OXFORDSHIRE COUNTY COUNCIL'S RESPONSE TO CONSULTATION ON THE FOLLOWING DEVELOPMENT PROPOSAL

Application no: 22/03868/OUT

Proposal: Development of up to 65 homes including open space provision, parking, landscaping, drainage and associated works, with All Matters Reserved (appearance, landscaping, layout and scale) except for Access

Location: Land West Adj To Salt Way And West Of, Bloxham Road, Banbury

Opportunities and Considerations Plan

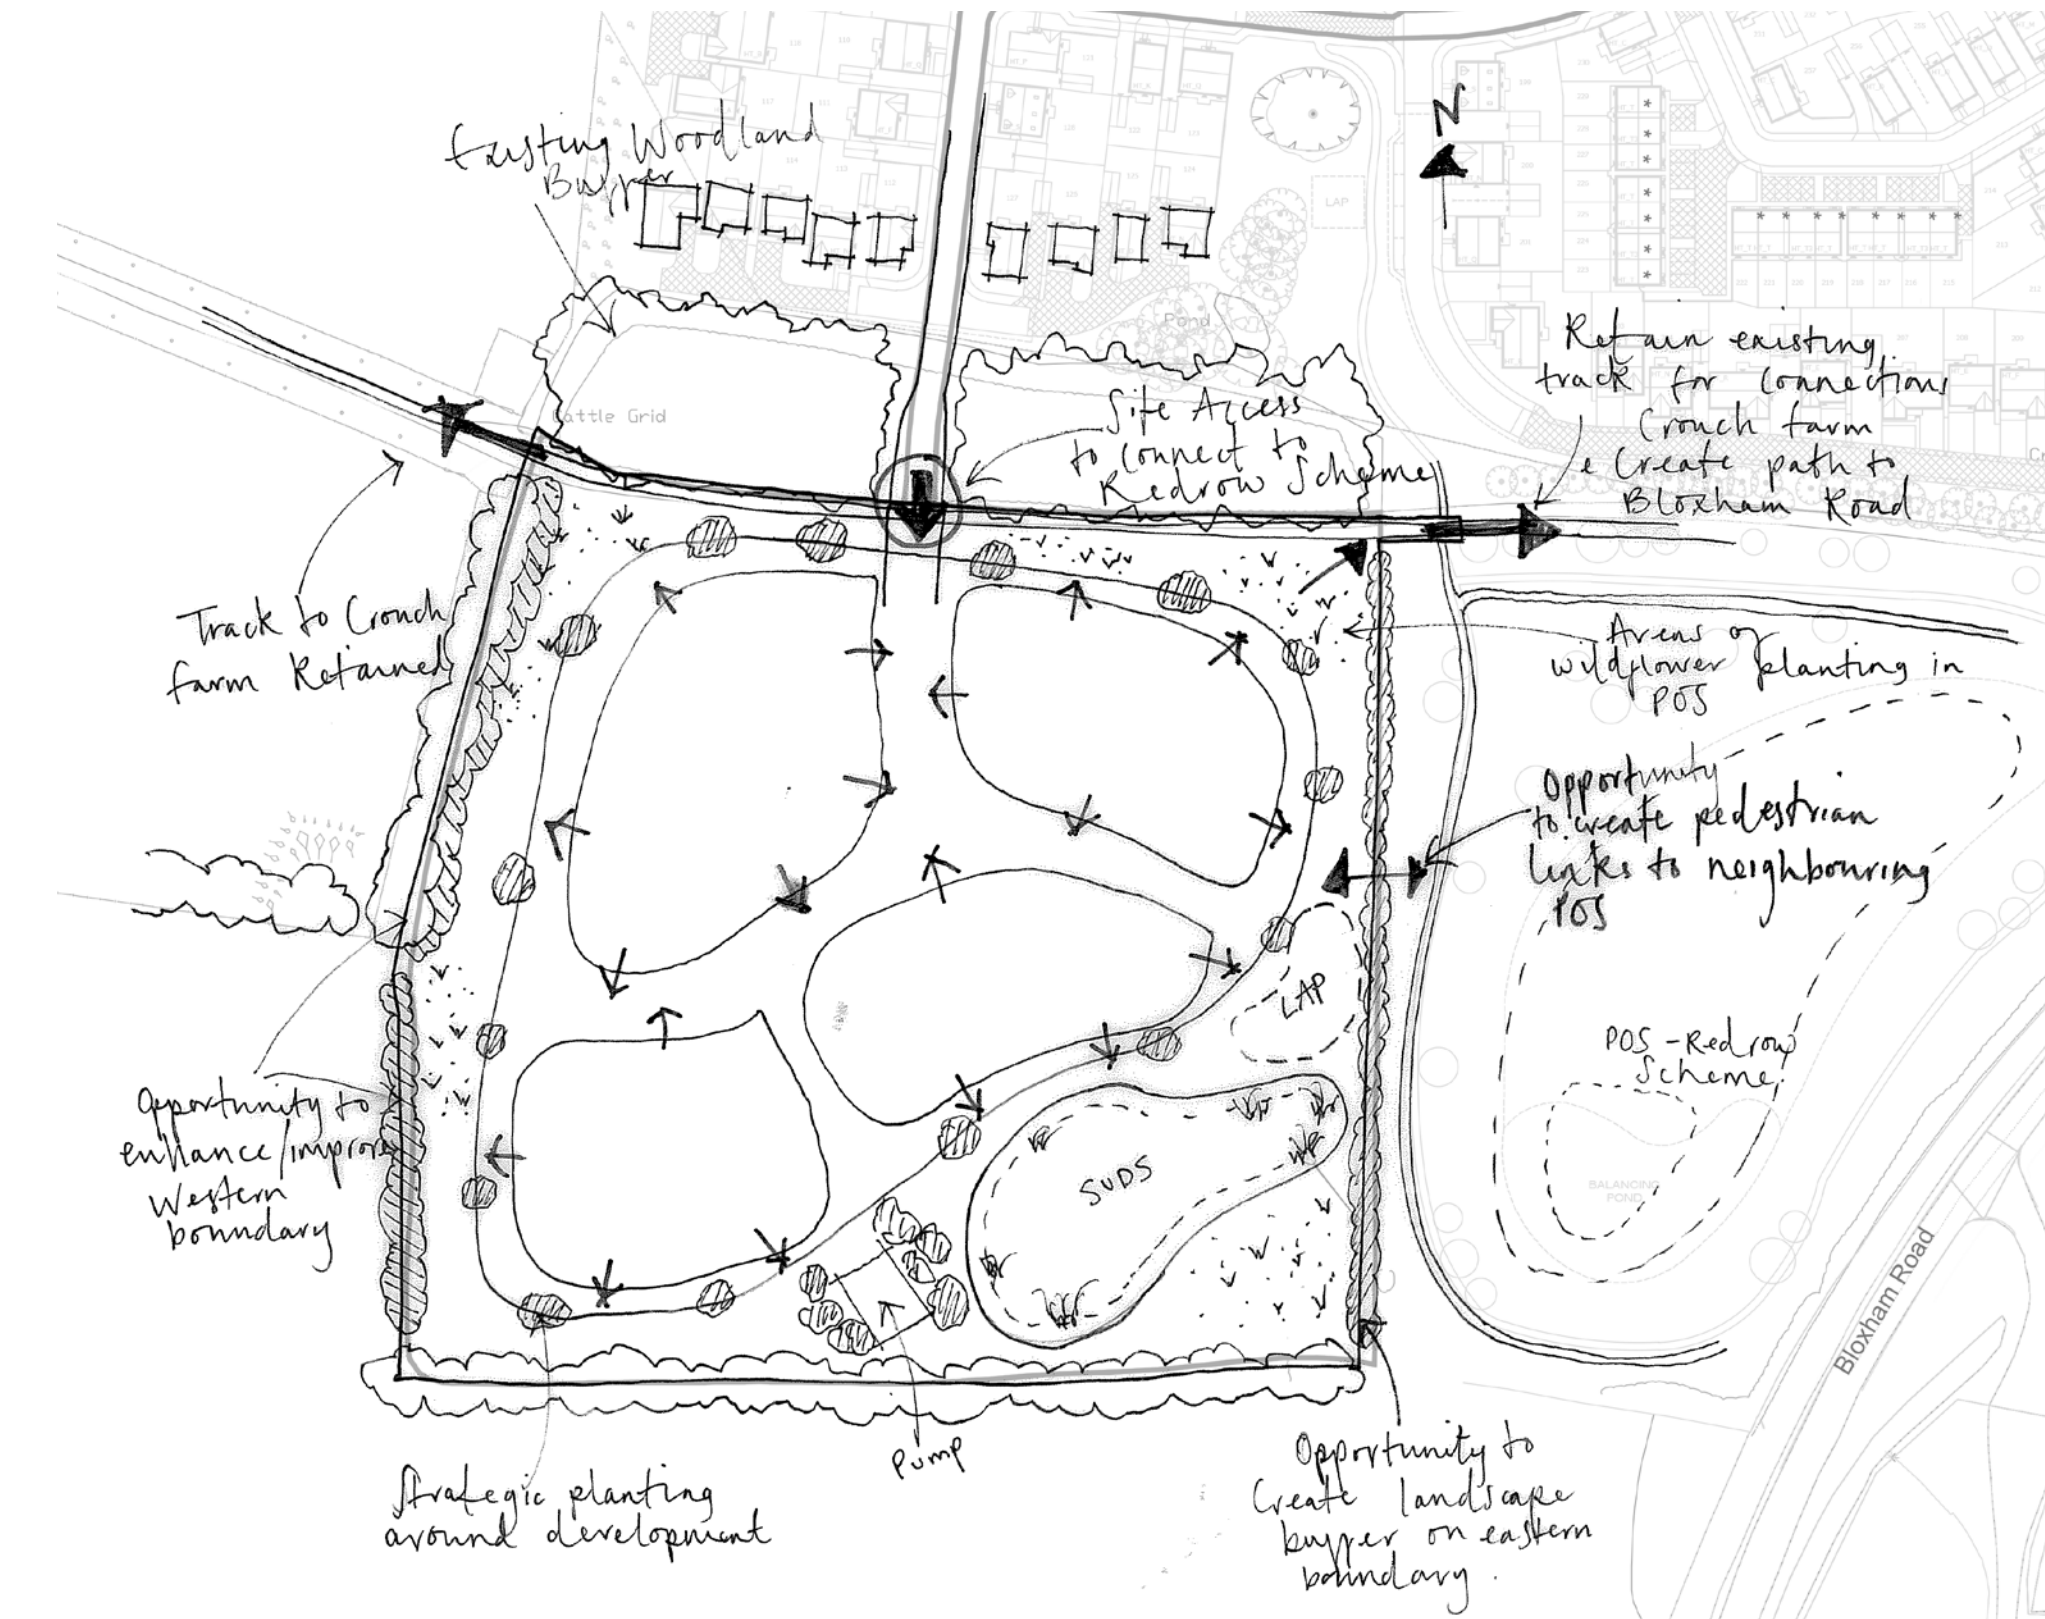
There is an inconsistency in the documentation regarding the pedestrian and cycle connections to the wider area. The Opportunities and Considerations Plan in the Design & Access Statement indicates a "Proposed footpath link via disused track to Bloxham Road", as shown in light blue below:

This link is not mentioned in the other documents, including the Landscape Strategy Plan, Parameters Plan or the Transport Statement. Given that there will be an opening

of some sort in the north-east corner, pedestrians and cyclists will tend to find a route out to the A361 via the open land next to the path. It connects to the pedestrian and cycle facilities adjacent to the new roundabout and is the most direct route to the bus stops. Furthermore, it will link up with the Public Right of Way 120/49 which heads southwards to Wykham Lane. A condition is requested to ensure that this track is maintained as a pedestrian and cycle route. This could be compatible with its use as an emergency access.
